From: Bruce Howse [REDACTED]
Sent: 18 October 2021 17:22
To: Anita Gardner <Anita.Gardner@arun.gov.uk>
Cc: Richard Wallis [REDACTED]
Subject: Re: A/180/21/DOC - Mayflower Way, Angmering - Construction Management Plan

From: Anita Gardner <Anita.Gardner@arun.gov.uk>
Date: Wednesday, 13 October 2021 at 09:45
To: Richard Wallis [REDACTED]
Subject: A/180/21/DOC - Mayflower Way, Angmering - Construction Management Plan

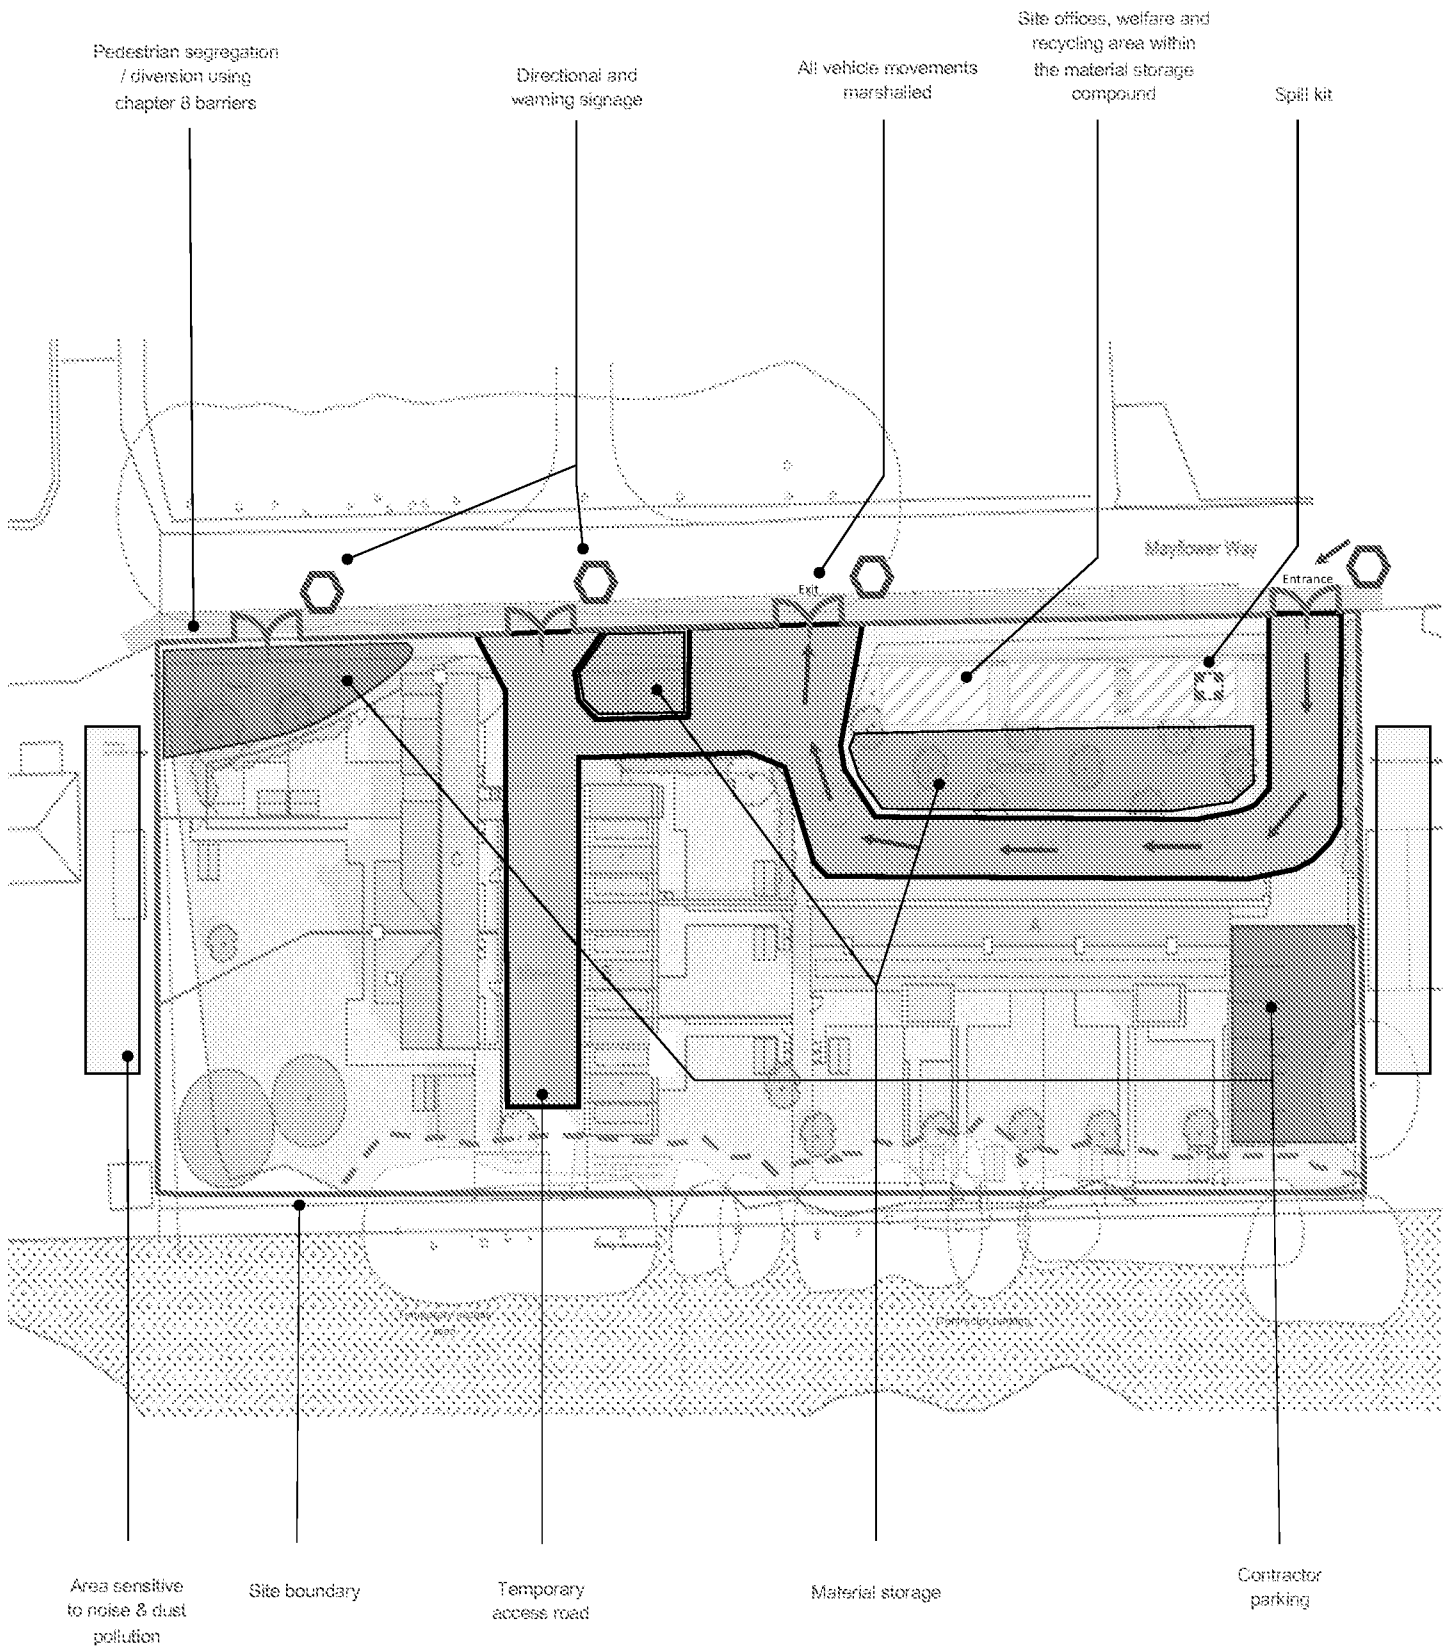
No agreement to discharge of Condition 6. The applicant will be aware of the predominantly peaceful nature of this area. It is therefore of concern to note that both access to the site materials storage area, (which will include HGV deliveries/taking away) and to contractor car parking is proposed along the boundary with a bungalow/housing to the immediate east of the proposed new housing. There is a similar, but smaller, area of contractor parking proposed immediately onto the boundary with that property to the immediate west of the site.

The location of the site access way/materials storage is therefore far from ideal and in my opinion likely to result in noise detriment/nuisance to nearby sensitive receptors. I would request for the site access way and main materials store to be repositioned to a more central position along Mayflower Way. Perhaps, it would then be possible for the main area of contractor parking to be brought forward towards Mayflower Way to form a buffer to this bungalow.

Please could the applicant describe the type of vehicles which will be included in 'contractor parking' ie will this be for vans and private cars alone/other.

Please find enclosed an updated CMP layout plan, prepared by the contractor, in response to the comments from the EHO below. We hope this addresses the concerns such as to enable discharge of this condition.
